1756 Washington
10-1159

ONE AND TWO FAMILY	PLAN REVIEW	CHECKLIST
Soil type/Presumptive Load Value (Table R401.4.1)		
Component	Submitted Plan	Findings Revisions Date
STRUCTURAL		
Footing Dimensions/Depth (Table R403.1 & R403.1(1), (Section R403.1 & R403.1.4.1)	10" x 16" FTng	
Foundation Drainage, Fabric, Damp proofing (Section R405 & R406)	OK see foundation detail	
Ventilation/Access (Section R408.1 & R408.3) Crawls Space ONLY	N/A	
Anchor Bolts/Straps, spacing (Section R403.1.6)	OK see detail	
1 Lally Column Type (Section R407)	Shows 3- 2x12's - 7' span -	
Girder & Header Spans (Table R 502.5(2))	OVER span - need better framing detail	
Built-Up Wood Center Girder Dimension/Type	" "	(Jog in beam for stairs)
Sill/Band Joist Type & Dimensions	2x6 PT	
First Floor Joist Species Dimensions and Spacing (Table R502.3.1(1) & Table R502.3.1(2))	2x10's	
2 Second Floor Joist Species Dimensions and Spacing (Table R502.3.1(1) & Table R502.3.1(2))	2x10's main house -	Garage - need 2x12/30/10 carrying beam sized

rear elevation

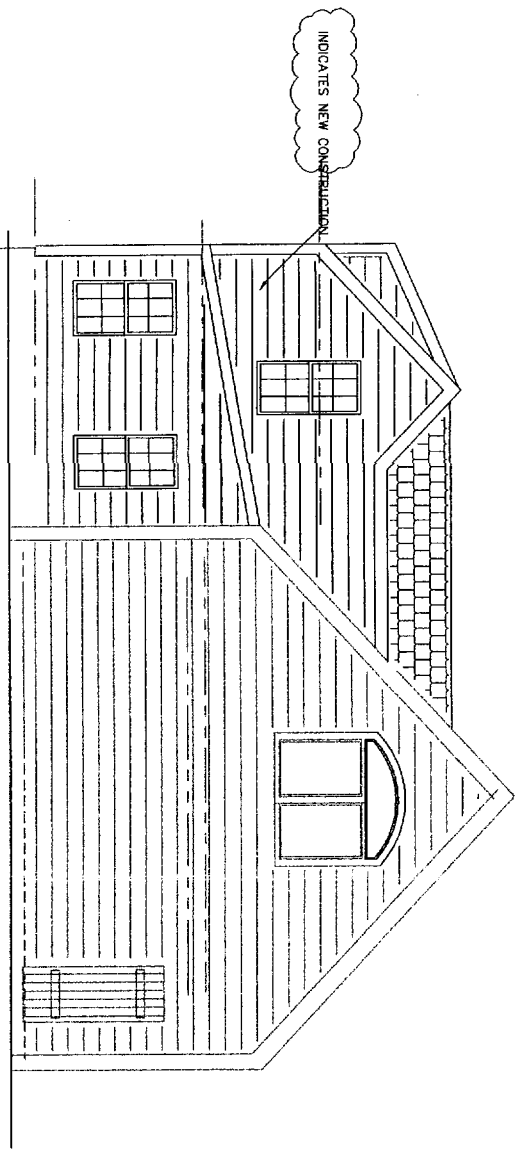
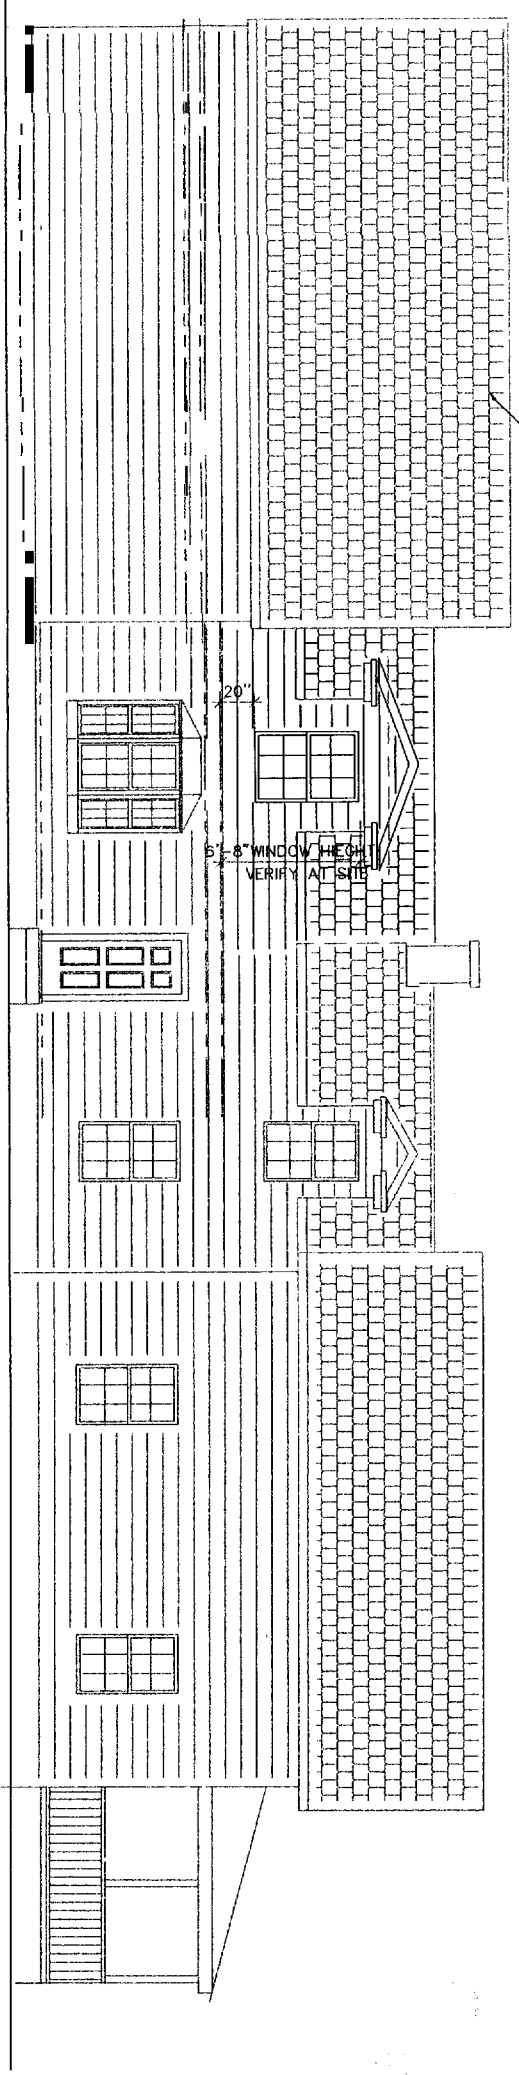
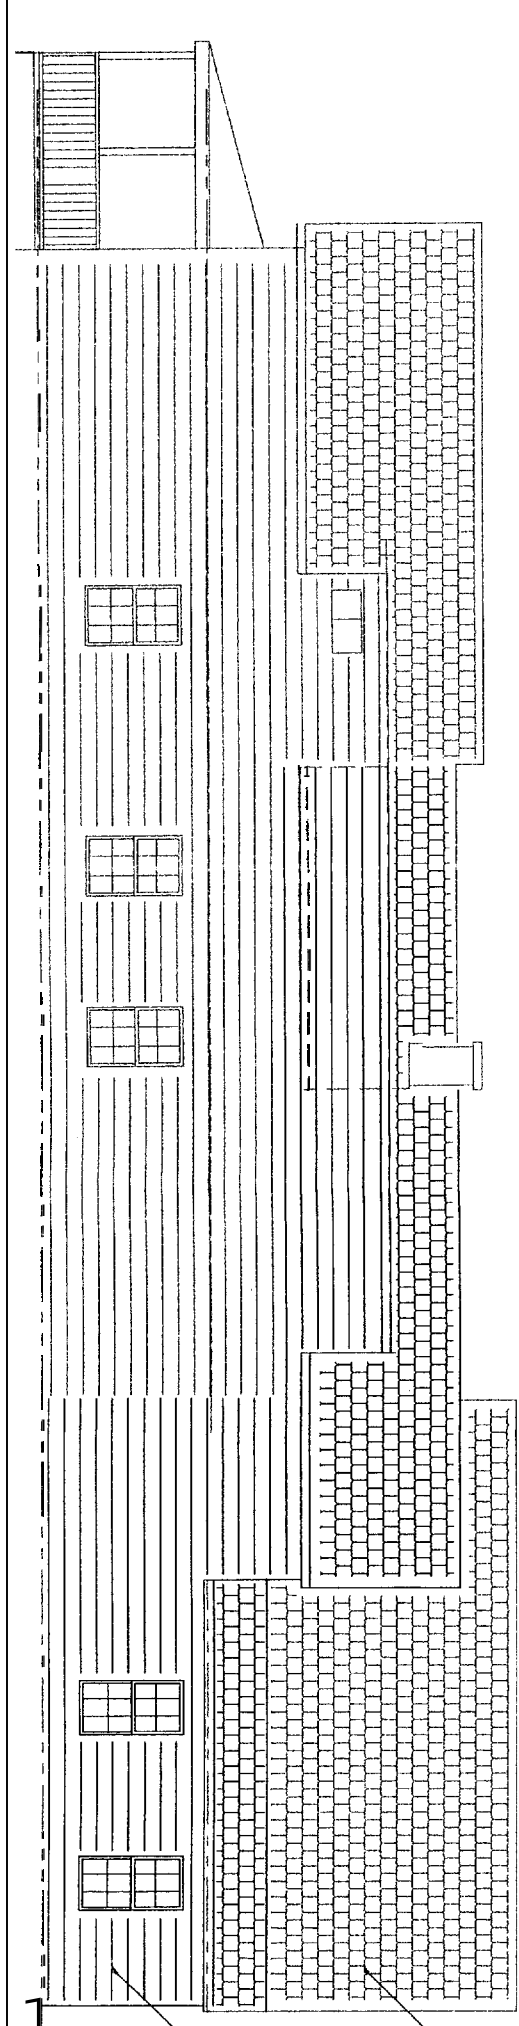
⑦ Elevations NOT Labeled correctly
